Engineers Comments Regarding Surface Water Drainage

NOTIFICATION FROM ARUN DISTRICT COUNCIL
Town & Country Planning Act 1990 (as amended)
Town and Country Planning (Development Management Procedure) (England) Order 2015
Planning Permission
APPLICATION NO: FP/185/19/PL

Registered: 22nd August
2019
Site Address: Mermaid and Playbox Sea Road Felpham PO22 7AW
Grid Reference: 494752 99202

Description of Works: Detached dwelling - Resubmission of FP/201/18/PL

BLOCK PLAN

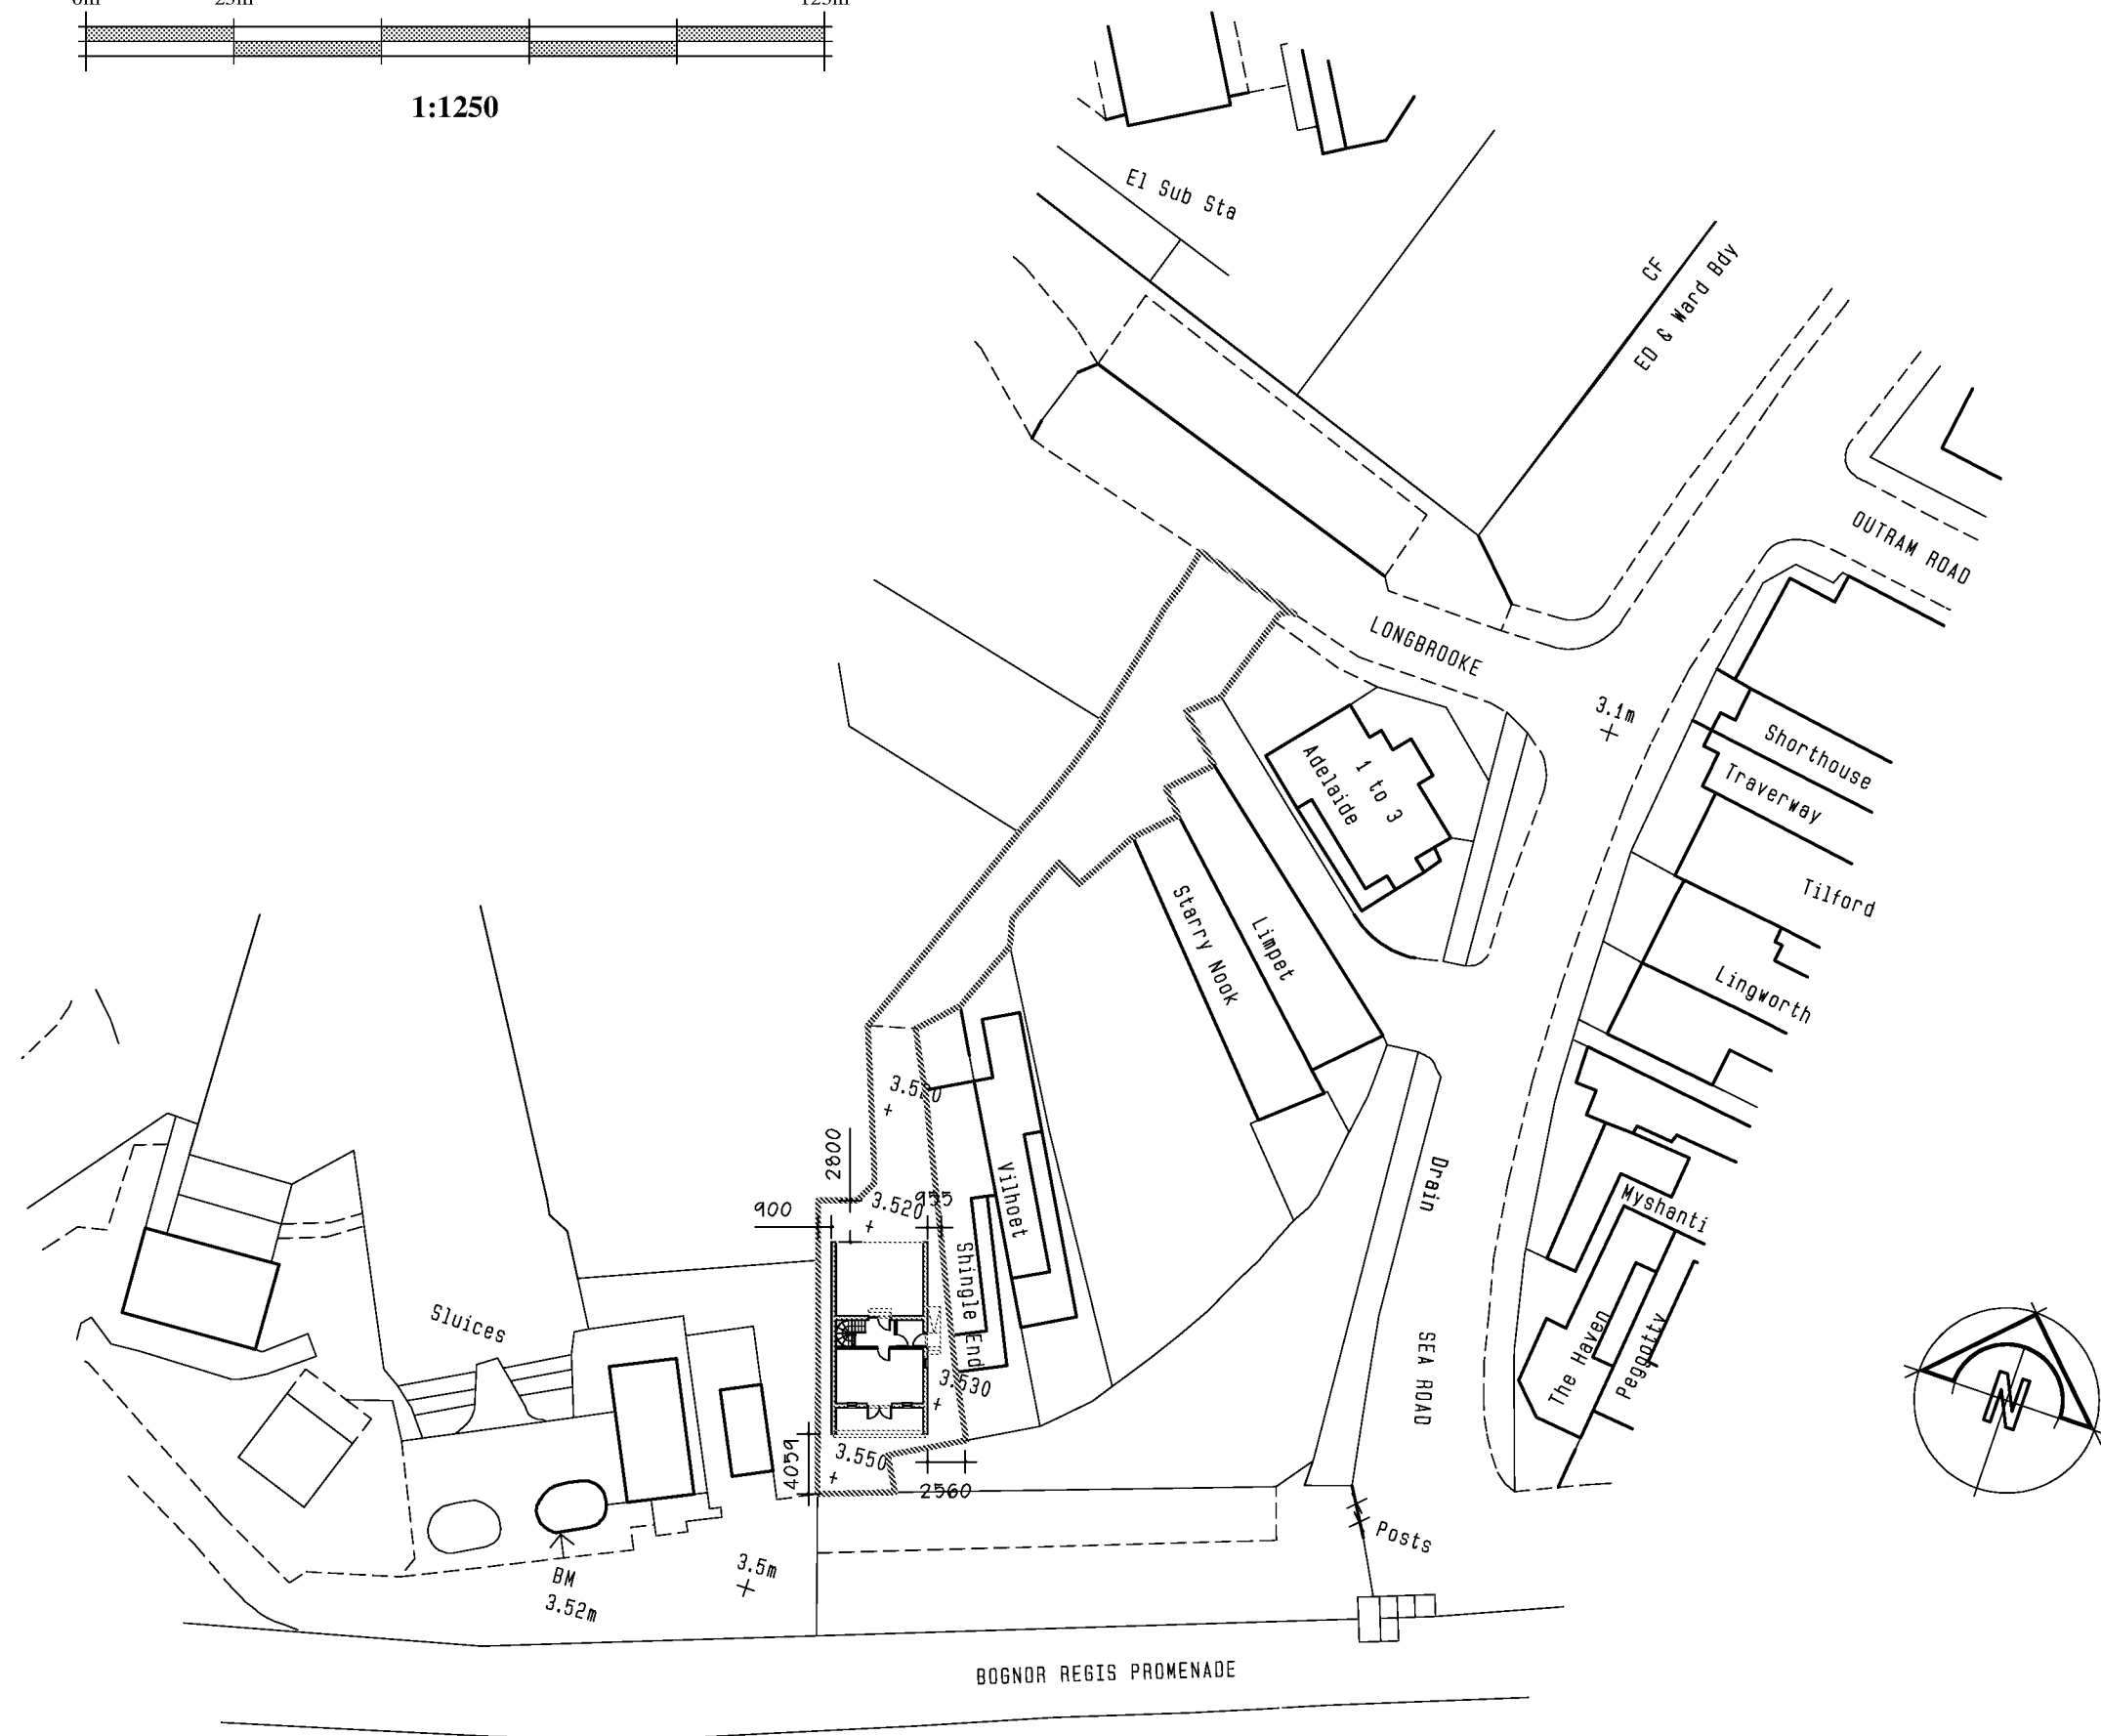
The application form states that surface water is to be disposed of to main sewer. Our records show that there is some distance from the building to the surface water sewer. Soakaways should first be considered. Surface water drainage design and construction must be in accordance with building regulations.
